Proposal: Replan of the western part of the residential development permitted through Reserved Matters application 19/00895/REM for the delivery of 107 dwellings

SUMMARY OF RECOMMENDATION: DELEGATE POWERS TO GRANT PERMISSION SUBJECT TO CONDITIONS AND A S106 LEGAL AGREEMENT

REV	DESCRIPTION	DATE	AUTH	CHK'D
REV A:	NDSS housetype re-elevated to suit neighbourhood character.	03.02.22	RH	IR
REV B:	Bed Spaces Updated	23.02.22	JD	IR
REV C:	NDSS 5 Person house	07.03.22	IR

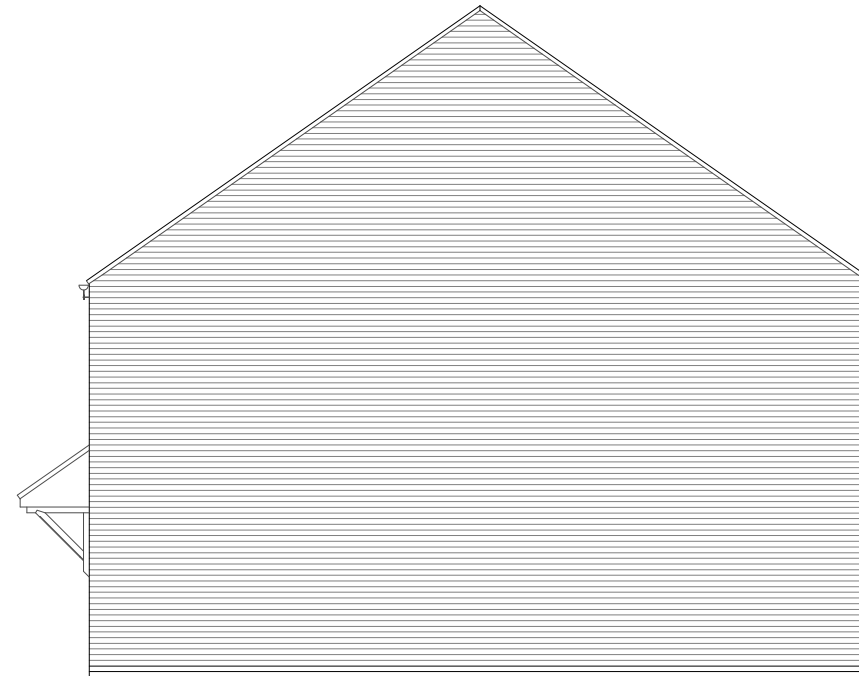
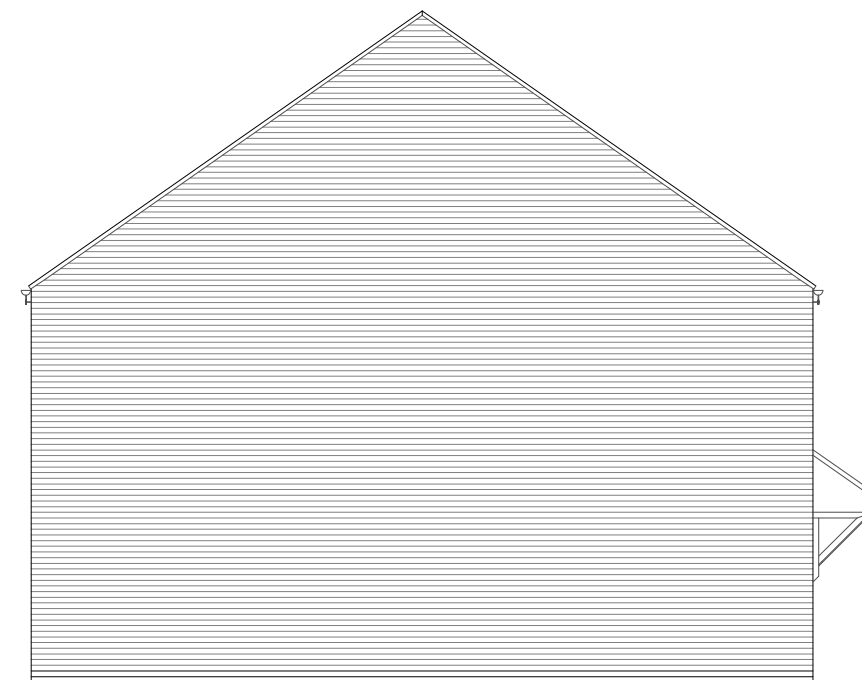
Update 18.02.2022 – the revised plans show that Type T50 dwellings have now been amended to comply with NDSS. However, type SH52 are still below NDSS and there is no acknowledgement or demonstration that 50% of the rented dwellings will meet M4(2) requirements. We are therefore **unable to support** this proposal until these matters have been rectified.

- 9.47. Following the receipt of amended plans, the revised plans show that type T50 dwellings have been amended and now comply with NDSS. However, Type SH52 remained below NDSS and there was no acknowledgement or demonstration that 50% of the rented dwellings would meet M4(2) requirements. The applicant's agent was advised that this must be rectified if the submission was to be considered acceptable. Further amended plans have now been received and assessed by Strategic Housing, who advise that the submission is now effective in meeting identified housing needs.

Further Update 9.3.22 – the Strategic Housing Team are appreciative that these dwellings are now 3-bed 5-person dwellings. The dimensions shown on the revised plans meet NDSS requirements for 3-bed 5-person houses and can confirm that these dwellings will now be effective in meeting identified housing needs.
